WEST SUSSEX COUNTY COUNCIL CONSULTATION

TO:	Arun District Council FAO: Sue Field
FROM:	Stephen Gee WSCC - Highways Authority
DATE:	2 June 2023
LOCATION:	Land East of Fontwell Avenue Fontwell
SUBJECT:	WA/56/22/PL Variation of condition imposed under WA/48/19/RES relating to condition 1-plans condition to allow an amendment to the non residential floorspace building at the entrance to the site (Block A) and the provision of 5 No new flats. This site also lies within the parish of Barnham and Eastergate. Additional information received from Sue Field's email on 19th May 2023.
DATE OF SITE VISIT:	n/a
RECOMMENDATION:	No Objection
S106 CONTRIBUTION TOTAL:	£28,155 + Deed of Variation

Date: FEB 23	Scales: 1:100 @ A1
Drawn: CA	Checked: Approved:
Drawing No.	4736/DAN/RET/06E

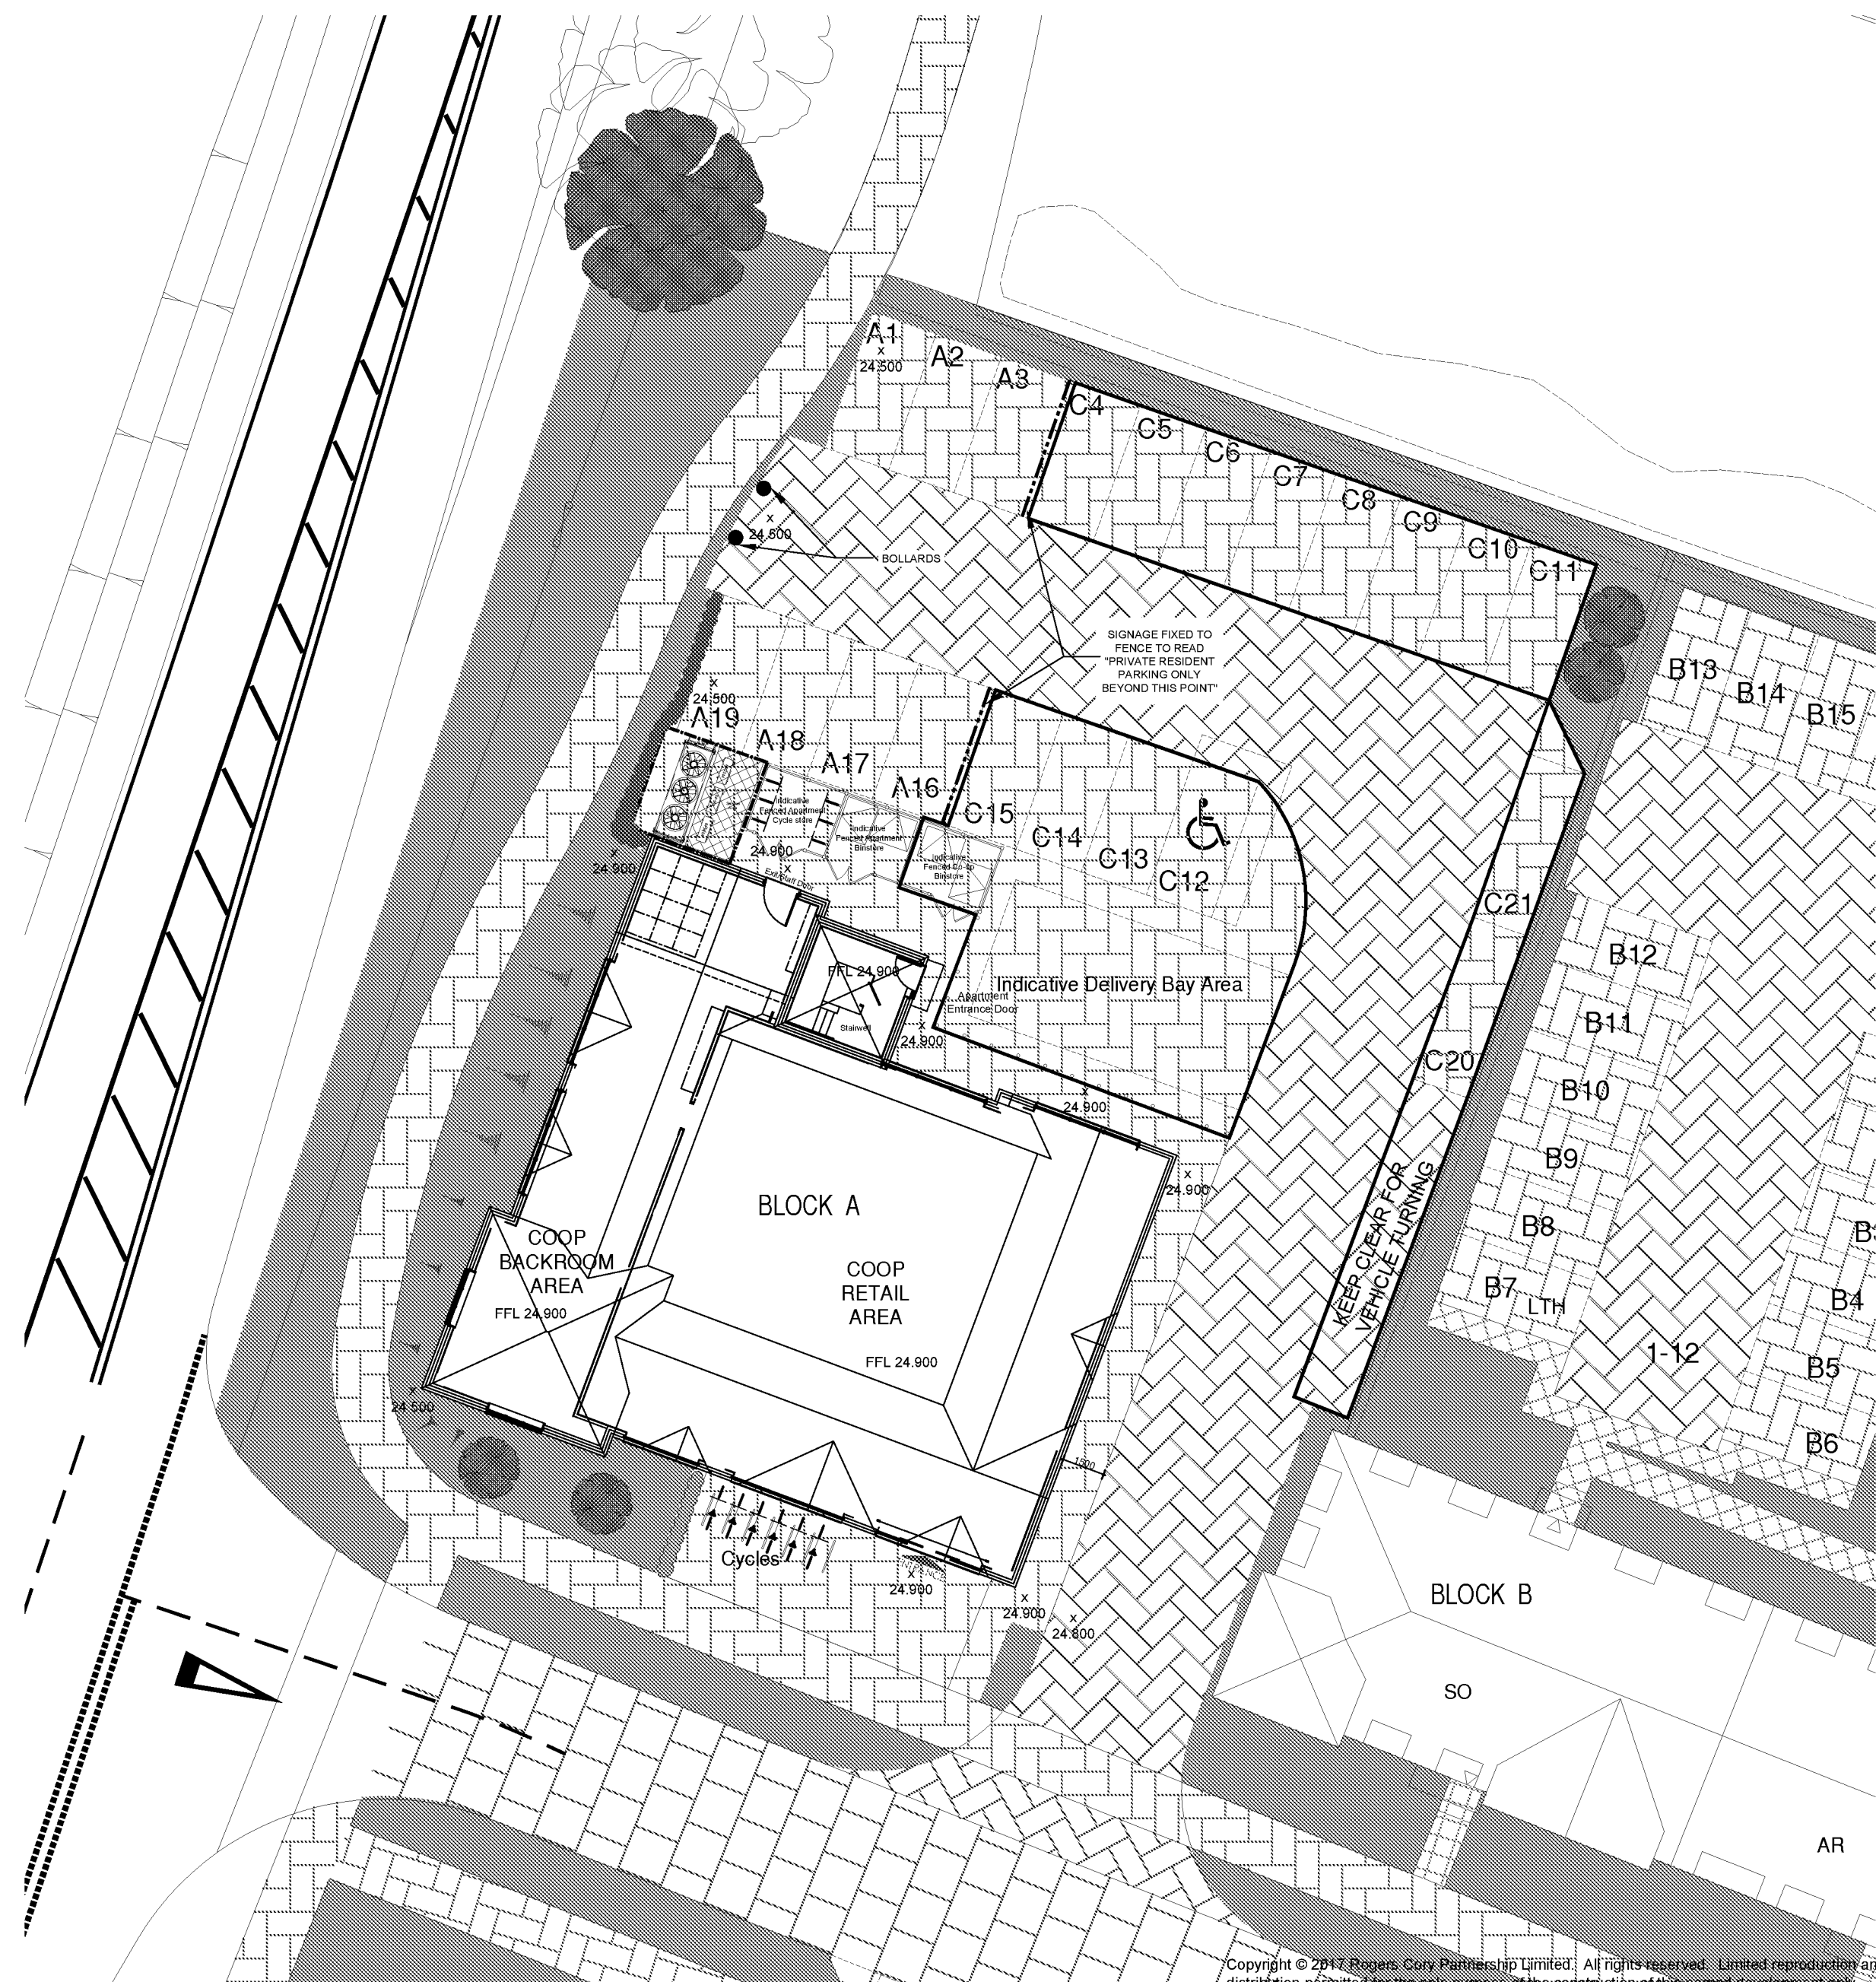
A location for the residential parking is shown on the revised plans. At present the store is fenced and does not appear to have a roof, residential cycle parking should be covered / secure. As such the suggested facility is not appropriate but the location is. The applicant has suggested the details could be secured via condition to which I would agree.

Provision for the retail unit is provided at the front of the store and is acceptable.

No part of the development shall be first occupied until covered and secure cycle parking spaces have been provided in accordance with plans and details submitted to and approved by the Local Planning Authority.
